Environment & Heritage

Your reference: MP09_0088
Our reference: EF14/6874
Contact: Calvin Houlison
(02) 4224 4179

I refer to your request for comments on the Applicants Response to Submissions relating to the Concept Plan for a proposed mixed use subdivision at West Culburra.

Attachment 1 OEH detailed comments on update West Culburra Water Quality Reports

7 Attachment C – Water Quality Monitoring Plan

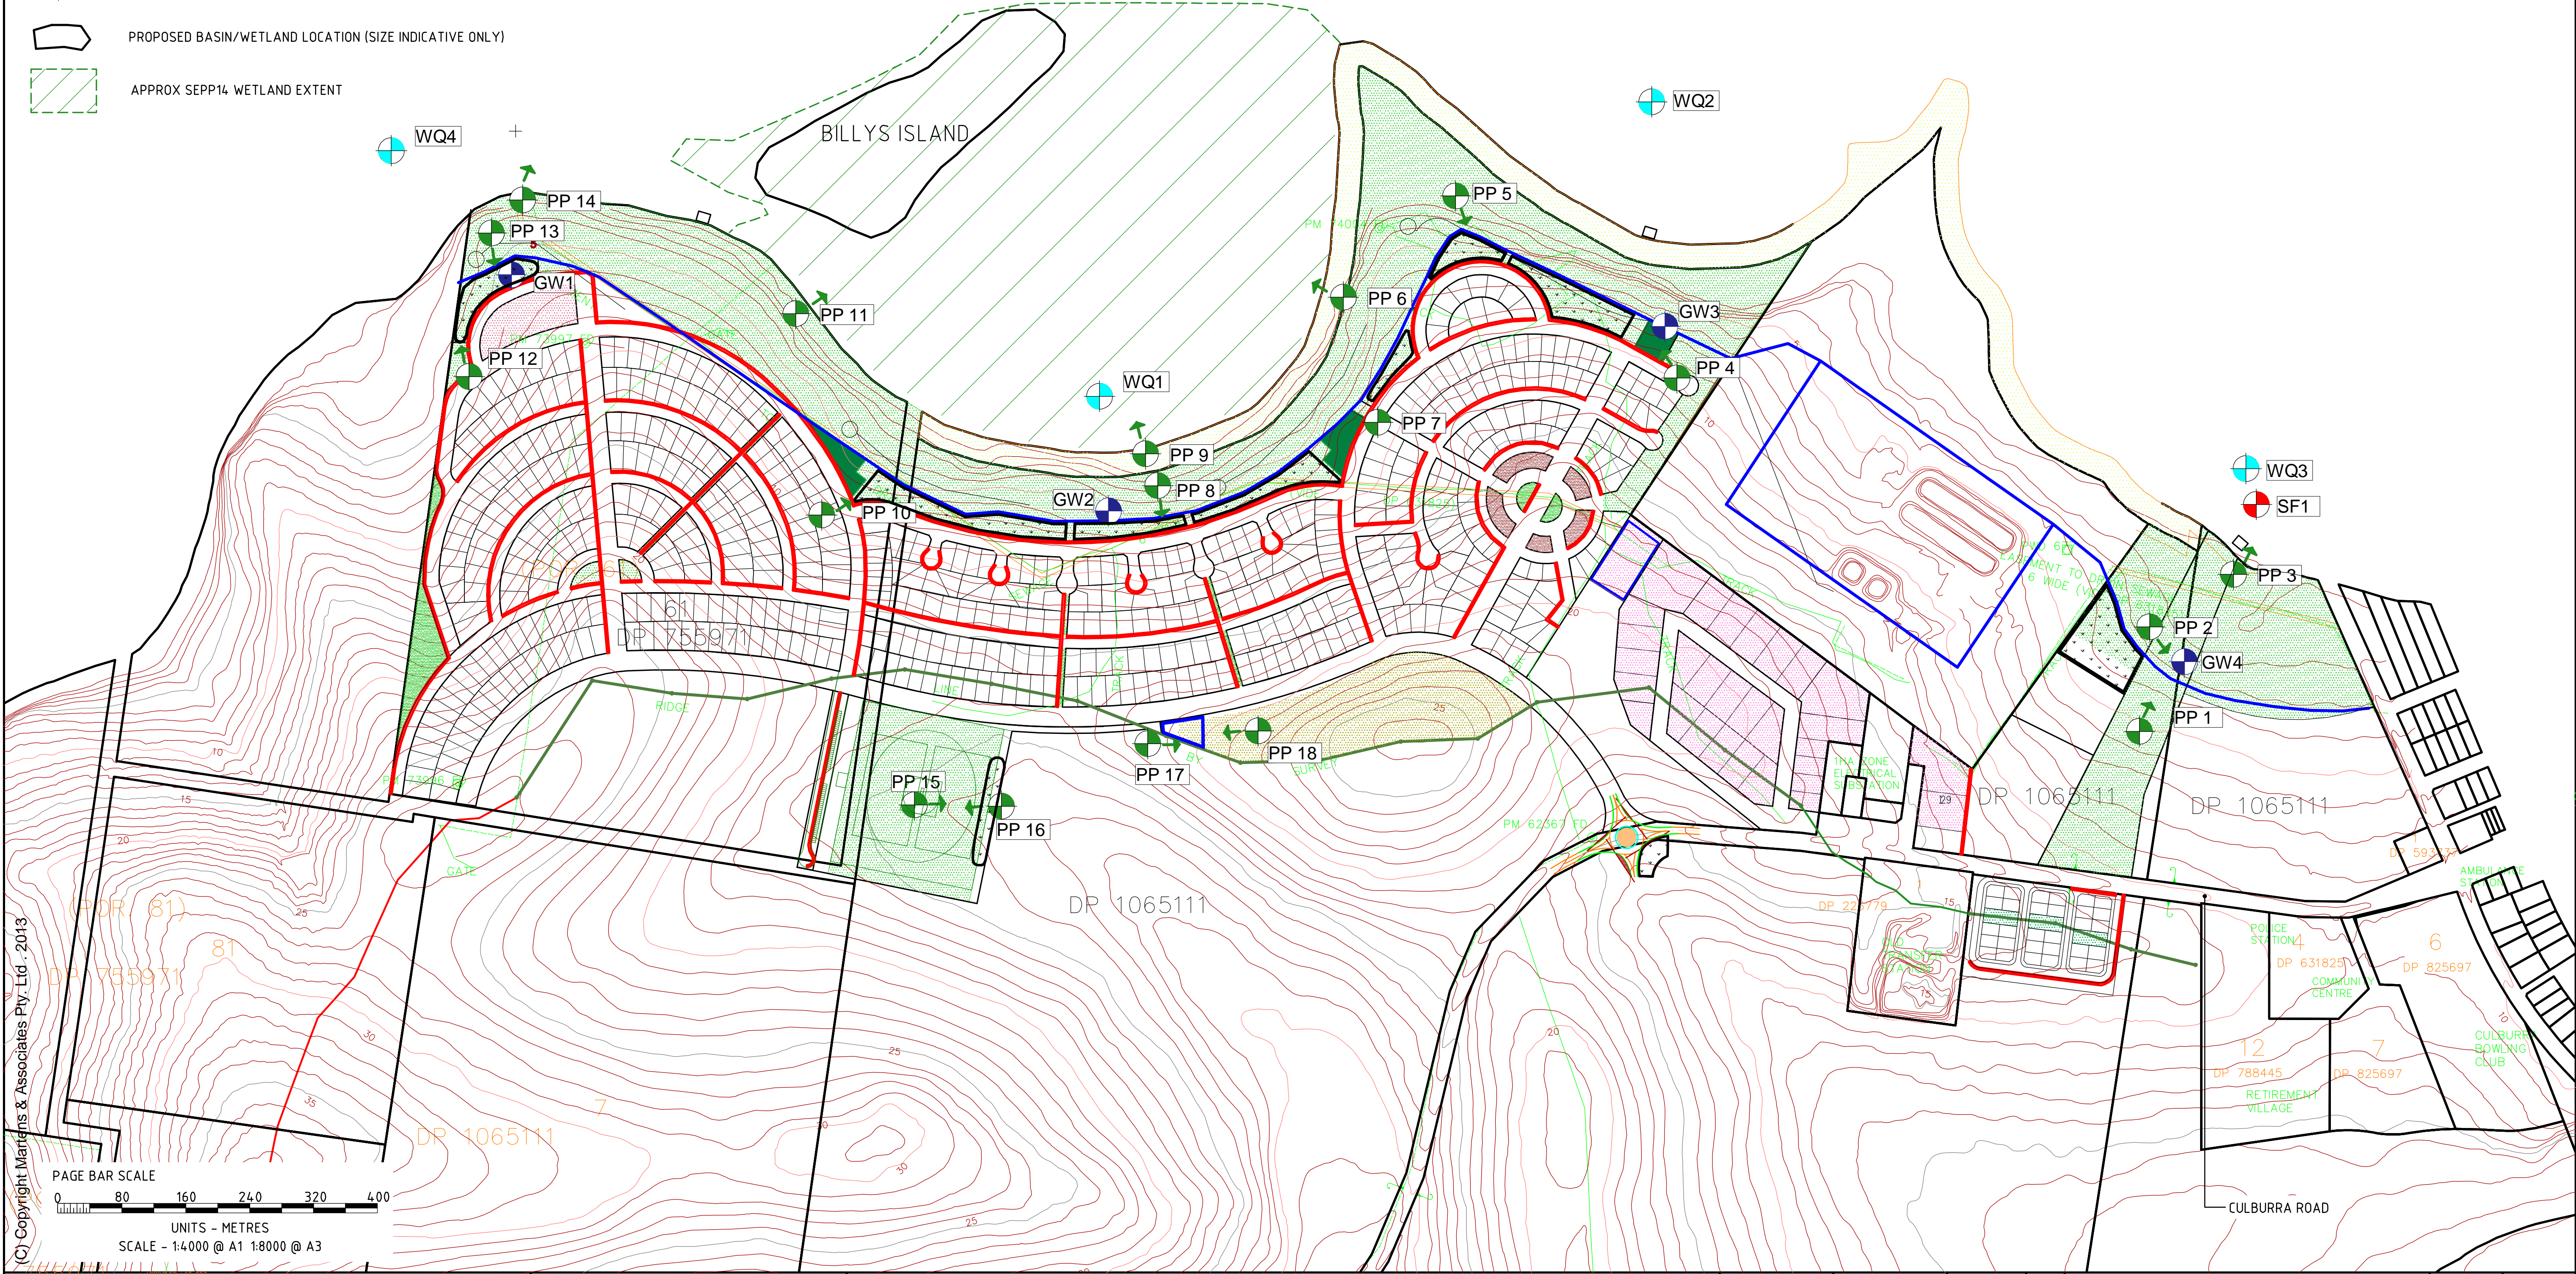
- The monitoring plan should include locations of the monitoring sites, clearly justified and mapped. The plan should confirm that monitoring sites WQ1 – WQ4 are in addition to the Council's existing monitoring.

- The monitoring plan should identify the parameters to be monitored, with justification for their selection.
 - The plan should confirm that monitoring of all parameters will be undertaken for all estuary water quality monitoring sites (i.e. WQ1 – WQ4), not just WQ4 (as indicated in Table 2 of the Water Quality Monitoring Plan).
